OXFORDSHIRE COUNTY COUNCIL'S RESPONSE TO CONSULTATION ON THE FOLLOWING DEVELOPMENT PROPOSAL

Application no: 23/00214/REM

Proposal: Reserved Matters Application pursuant to outline planning permission 14/02121/OUT for Phase 1A (infrastructure comprising two junctions to provide vehicular and pedestrian access into the site from Middleton Stoney Road and two initial sections of internal road) along with the partial compliance of conditions 12 (Building for Life 12), 16 (means of vehicular access), 17 (means of pedestrian/cycle links) and 19 (detailed surface water drainage scheme) for Phase 1A.

Location: Proposed Himley Village North West Bicester, Middleton Stoney Road, Bicester

TITLE MIDDLETON STONEY ROAD, MAIN SPINE ROAD JUNCTION. GENERAL ARRANGEMENT SHEET 1	
HYDROCK PROJECT NO. C-27141-C	SCALE @ A2 1 : 500
STATUS DESCRIPTION INFORMATION	STATUS S2
DRAWING NO. (PROJECT CODE-ORIGINATOR-ZONE-LEVEL-TYPE-ROLE-NUMBER) 27141-HYD-XX-XX-DR-D-0001	REVISION P02

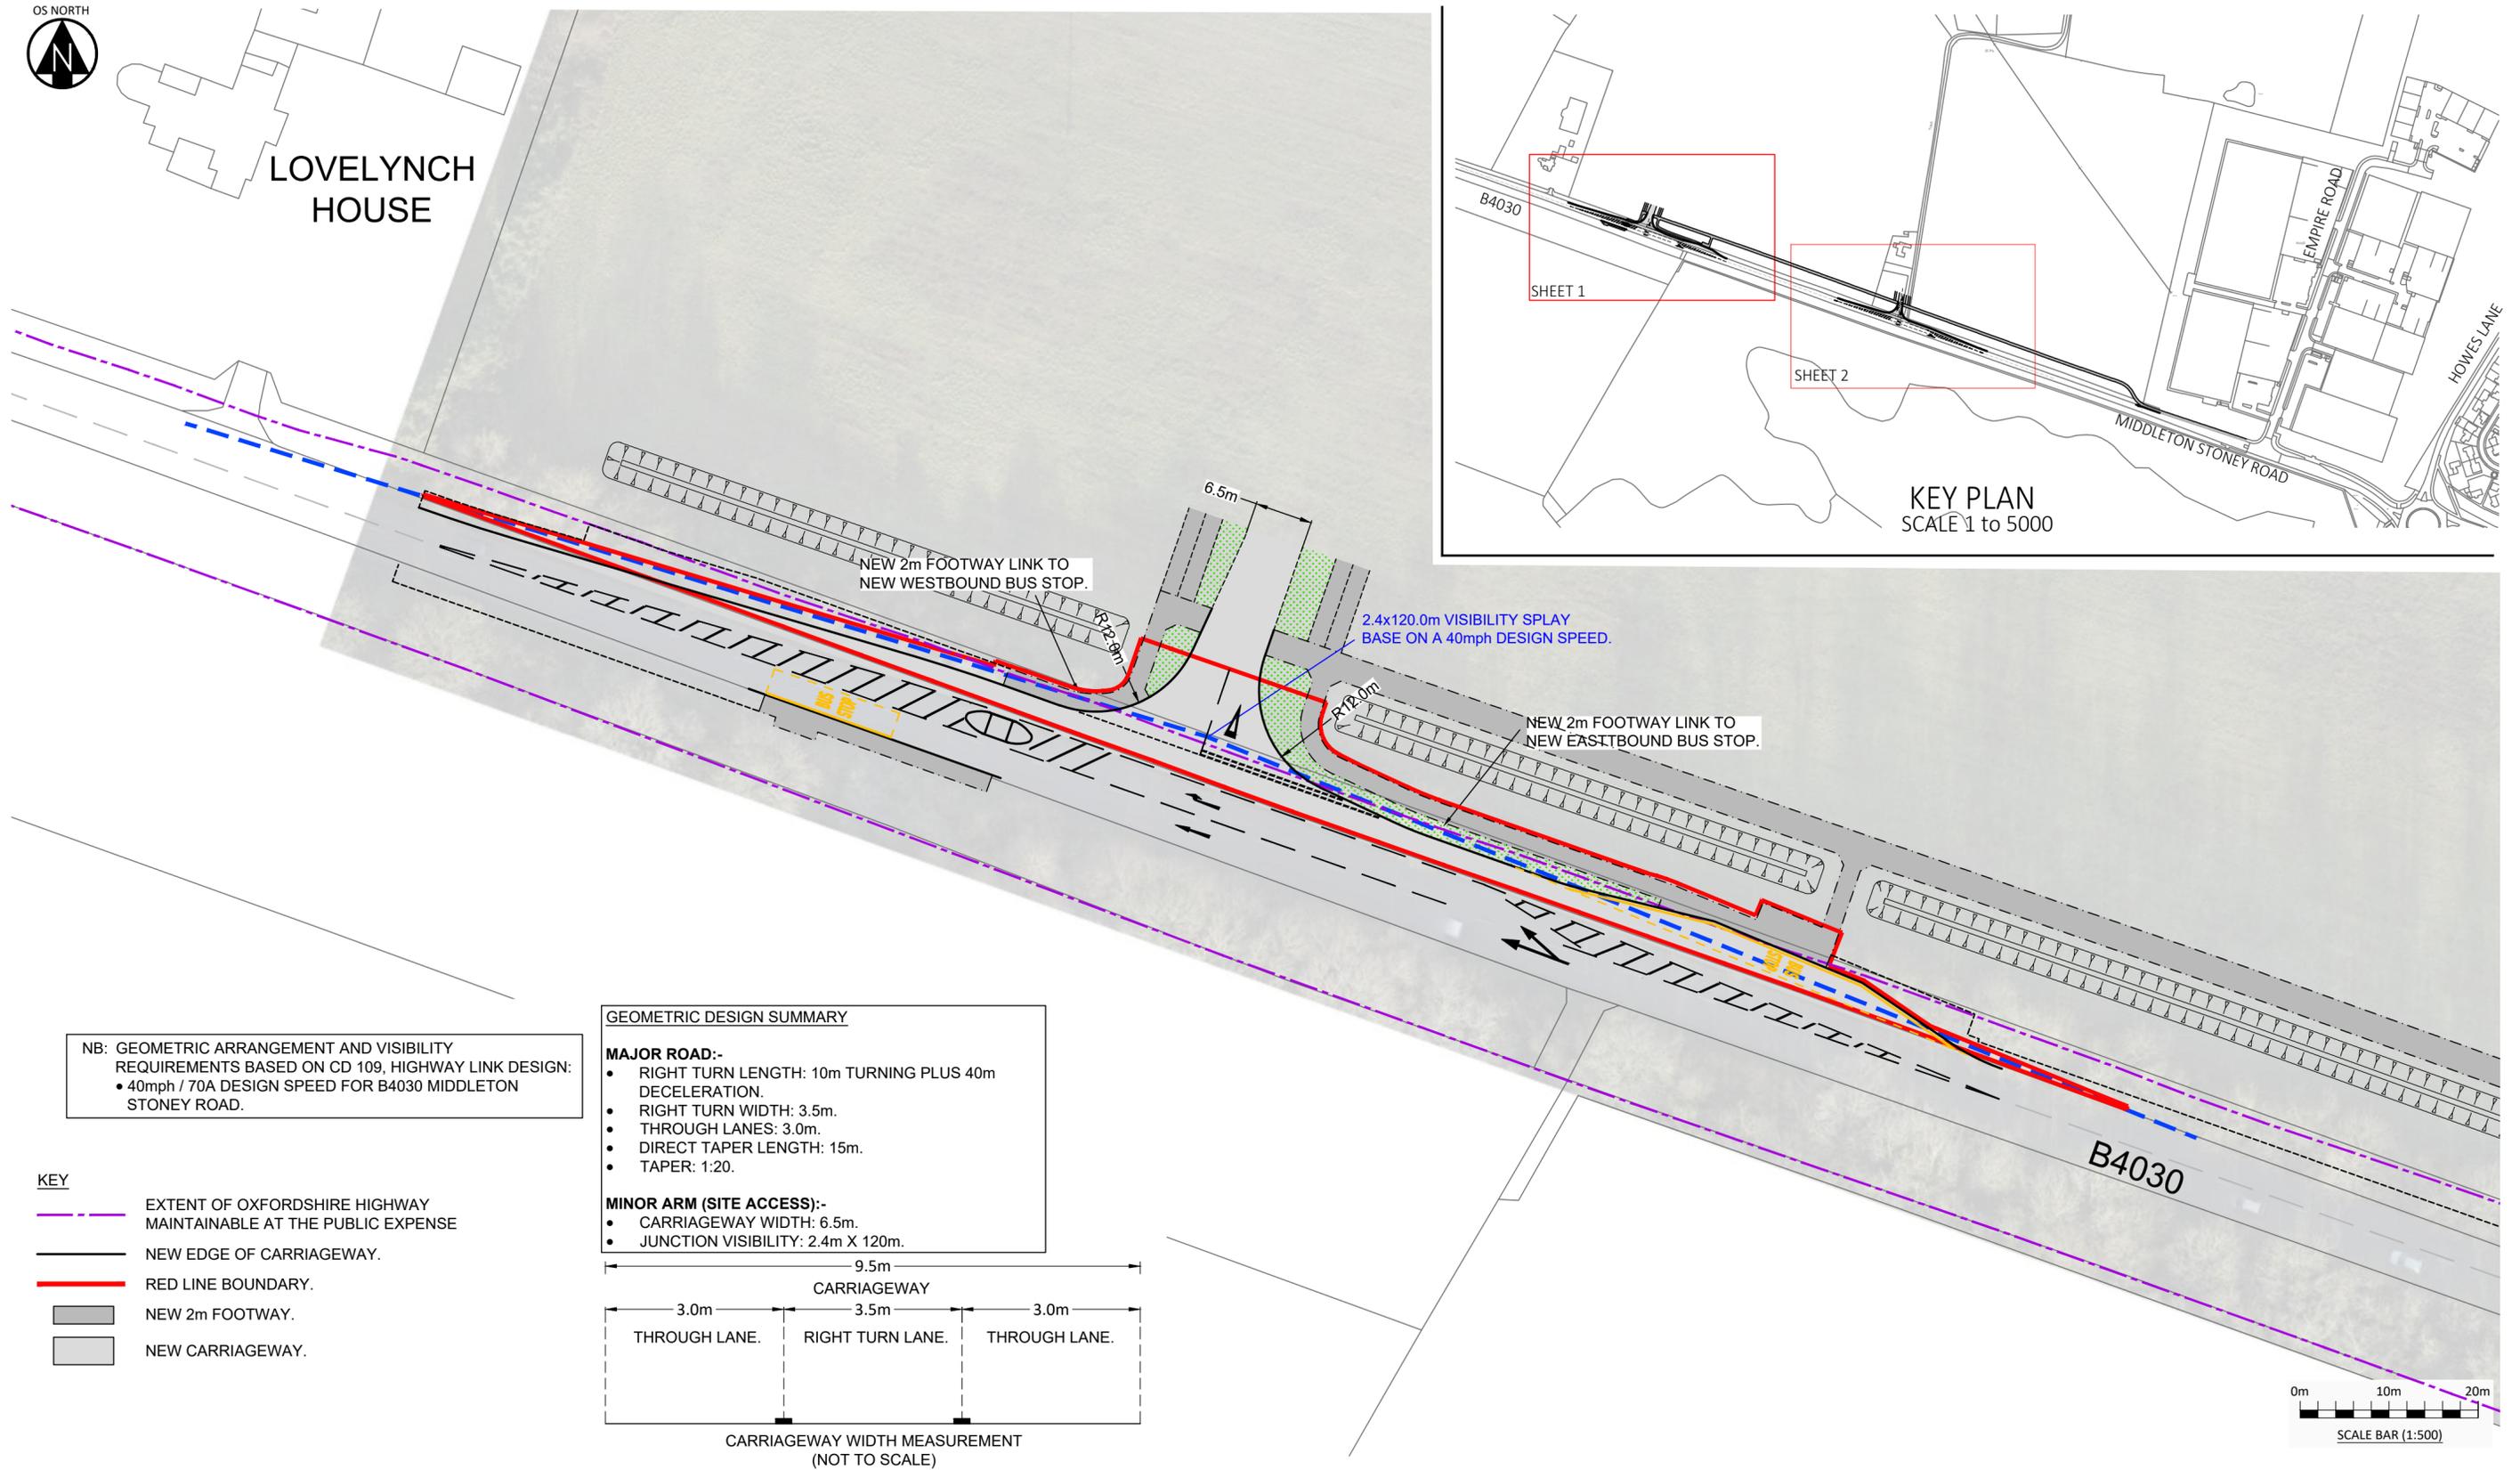
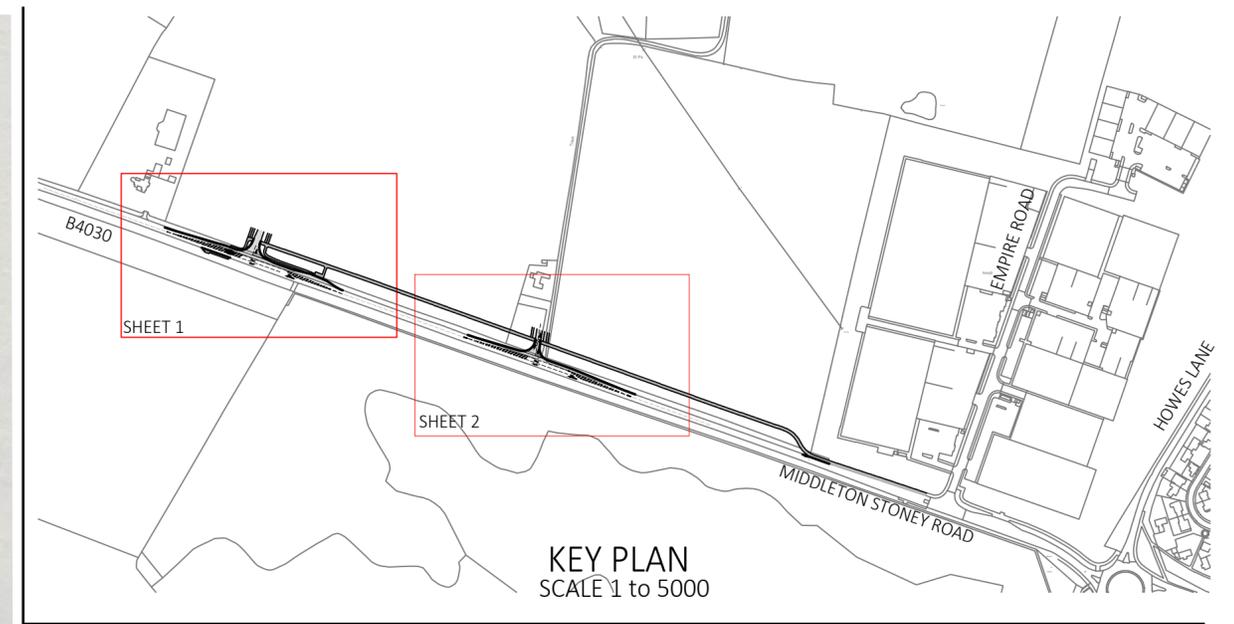
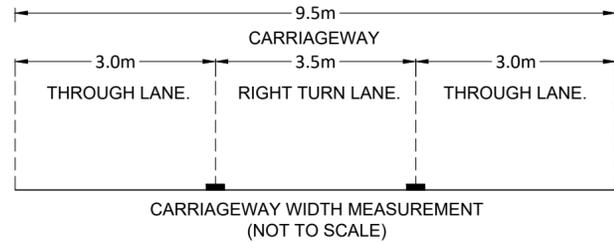
The red line area has been amended (on drg. 0001 Rev. P02) to incorporate a revised footway arrangement to the two bus stops. This tallies with the adjusted footway and cycle lane provision, as separately agreed, along the Spine Road, as shown on Rev. P03 of the Pedestrian & Cycle Link (Permanent) GA drg. no. 0006.

Details of the access will be finalised during the technical approval process of the Section 278 application.

TITLE  
MIDDLETON STONEY ROAD,  
SECONDARY ROAD JUNCTION.  
GENERAL ARRANGEMENT  
SHEET 2

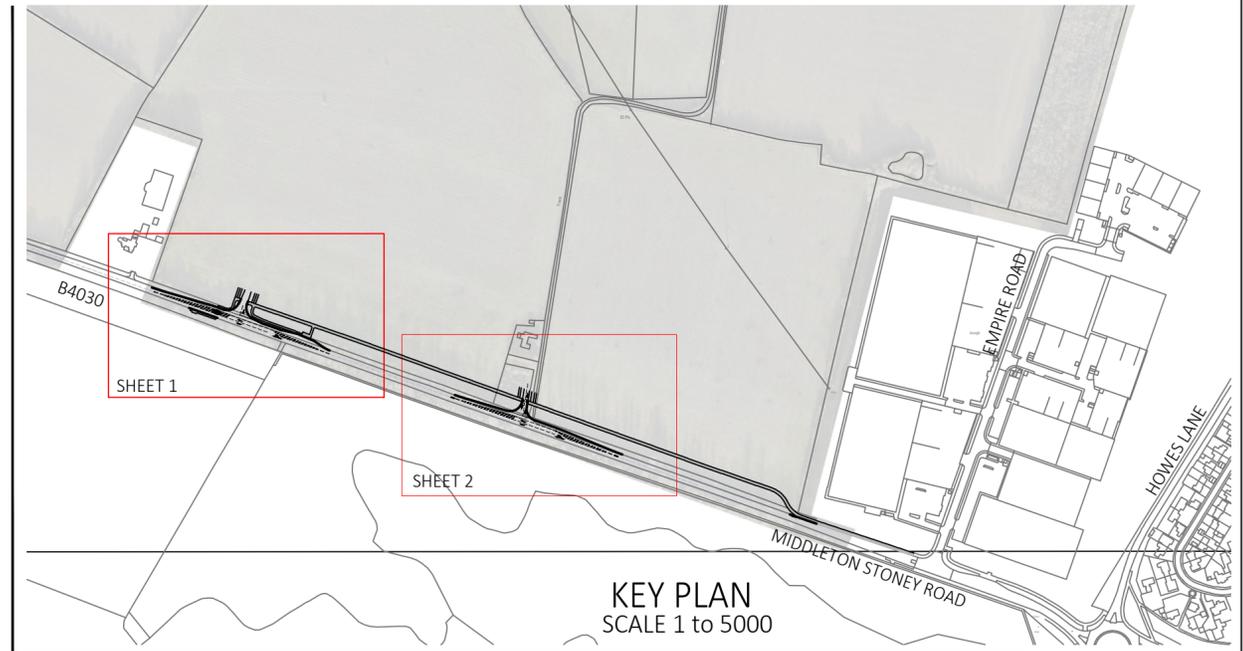
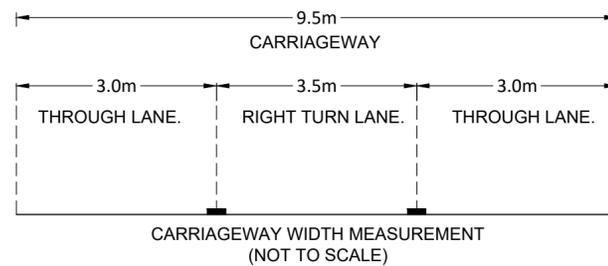
The red line area is similar to that shown on the previous revision. Pedestrian and cycle facilities, as agreed, outside of the area have been added for clarity.

The previous reason for objection, that the 5.5m width of the secondary road is too narrow for a bus service, has been addressed in separate correspondence. Adequate public transport provision will be achieved for an interim period from the service on Middleton Stoney Road prior to buses entering the site via the primary access road and the adjoining

Axis J9 development. Therefore, buses will not route via the secondary road, and the 5.5m width is acceptable.

Details of the access will be finalised during the technical approval process of the Section 278 application.
